July 5, 2022

John Green, Planner II

Re: Guntzelman Porcelain Pines Subdivision Letter of Intent

PRELIMINARY PLAN

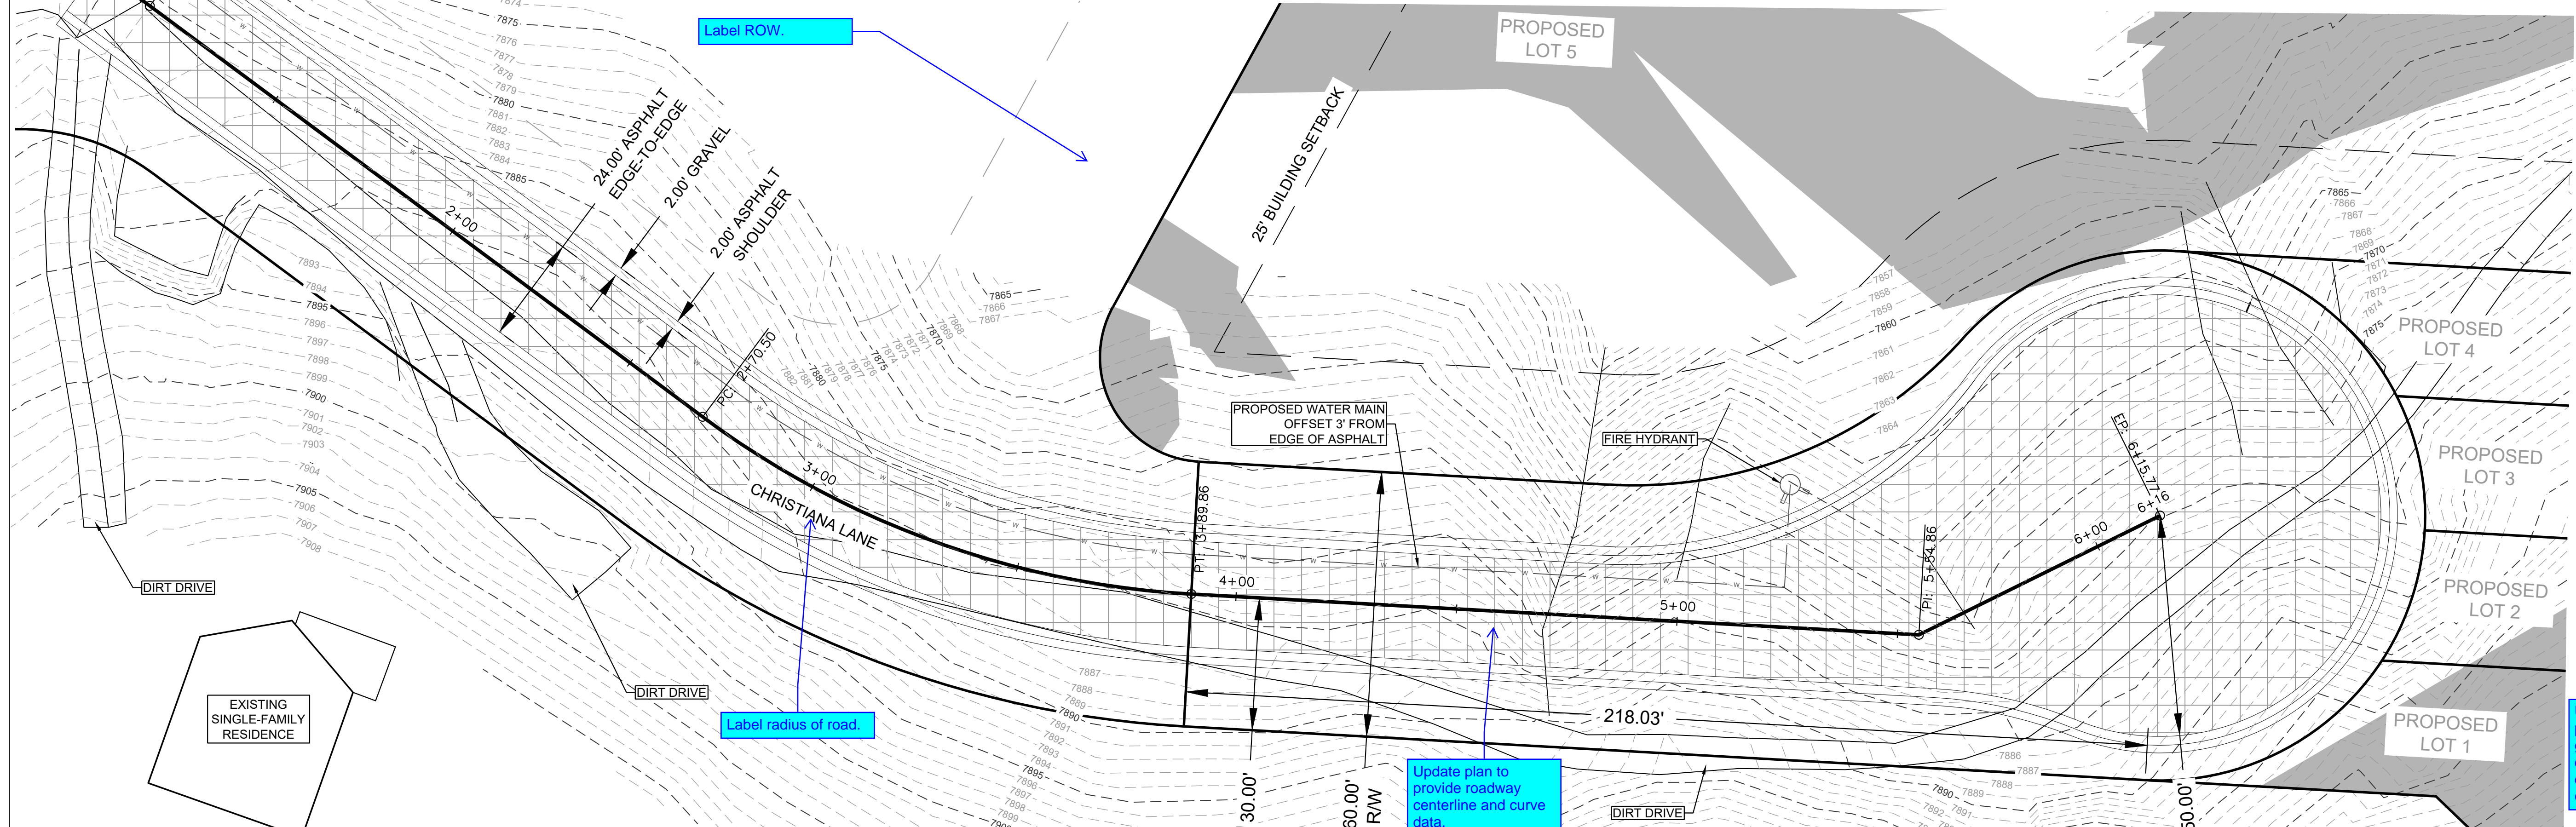
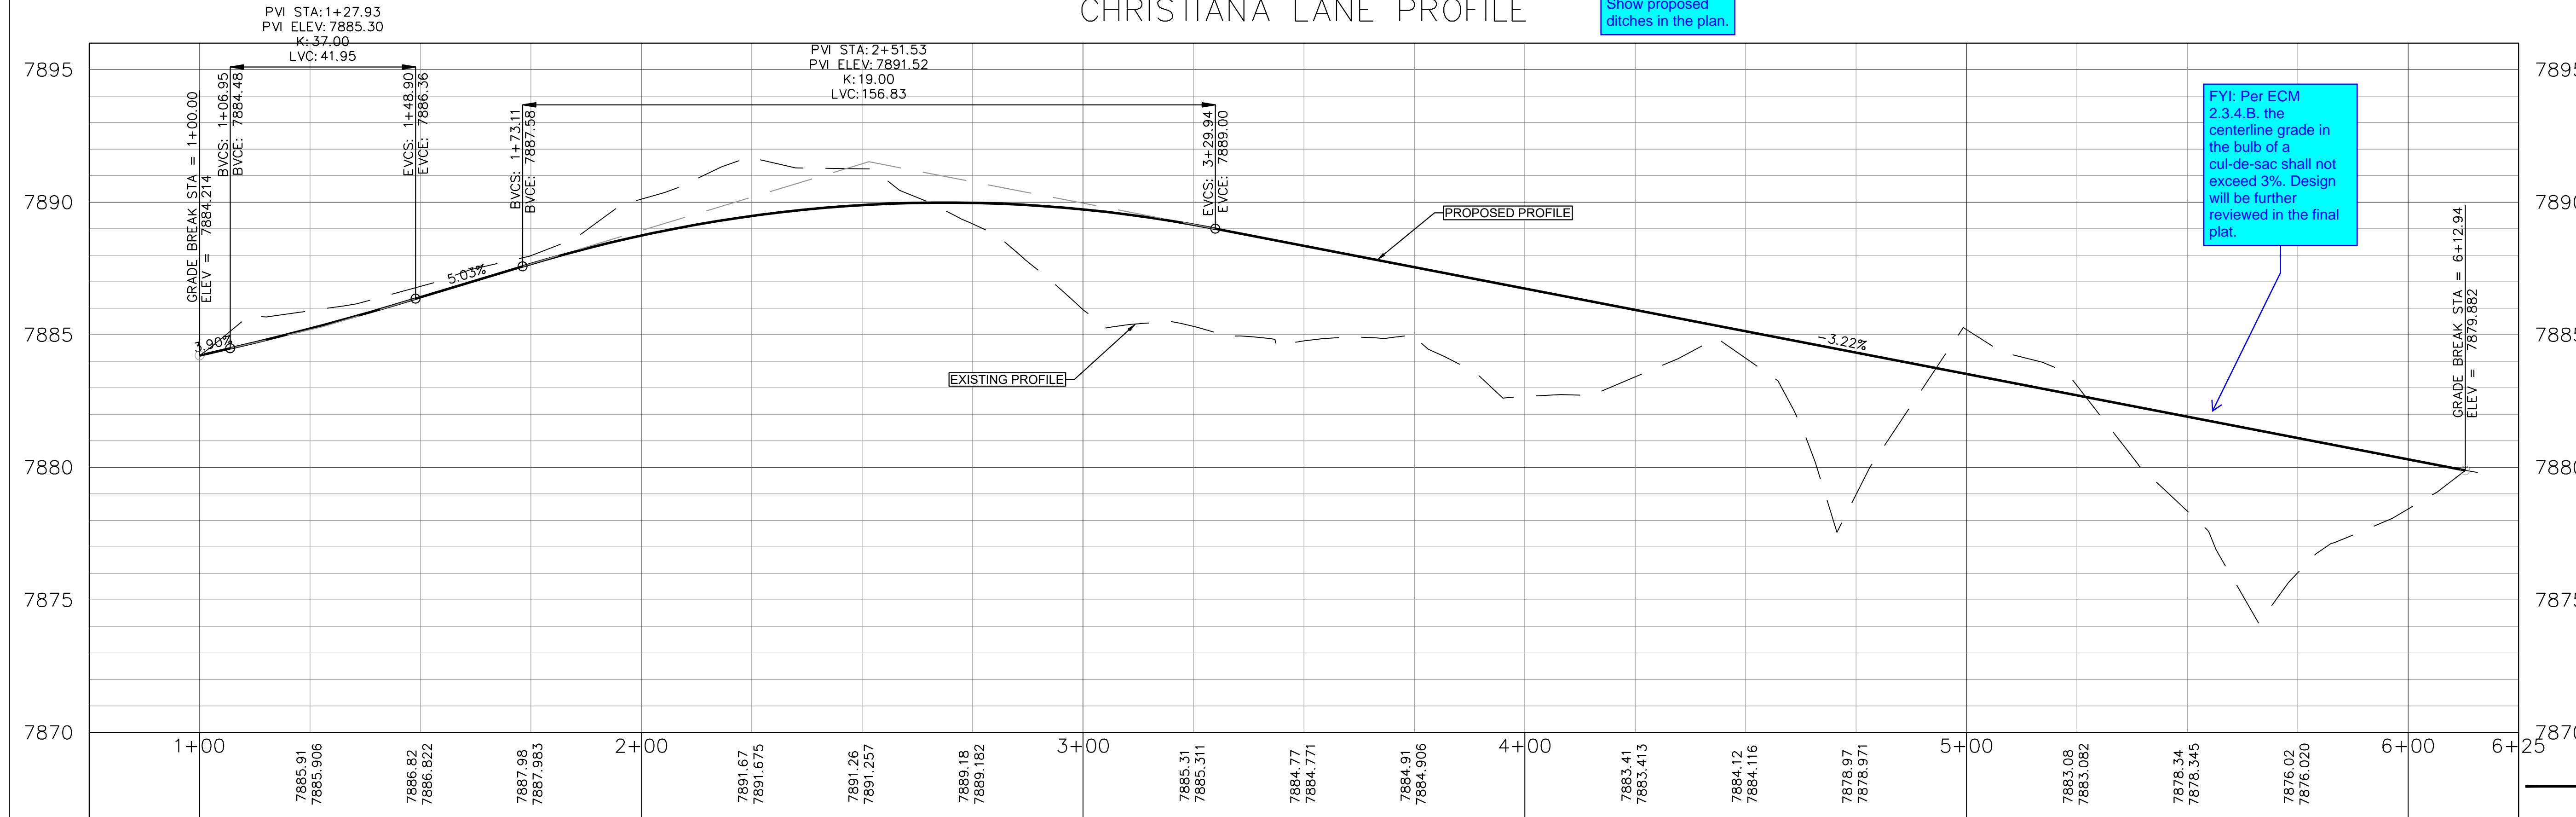
show unstable areas on the drawing.

This road is called Christiana Lane on the map. Will that be the street name? If so, please keep the name.
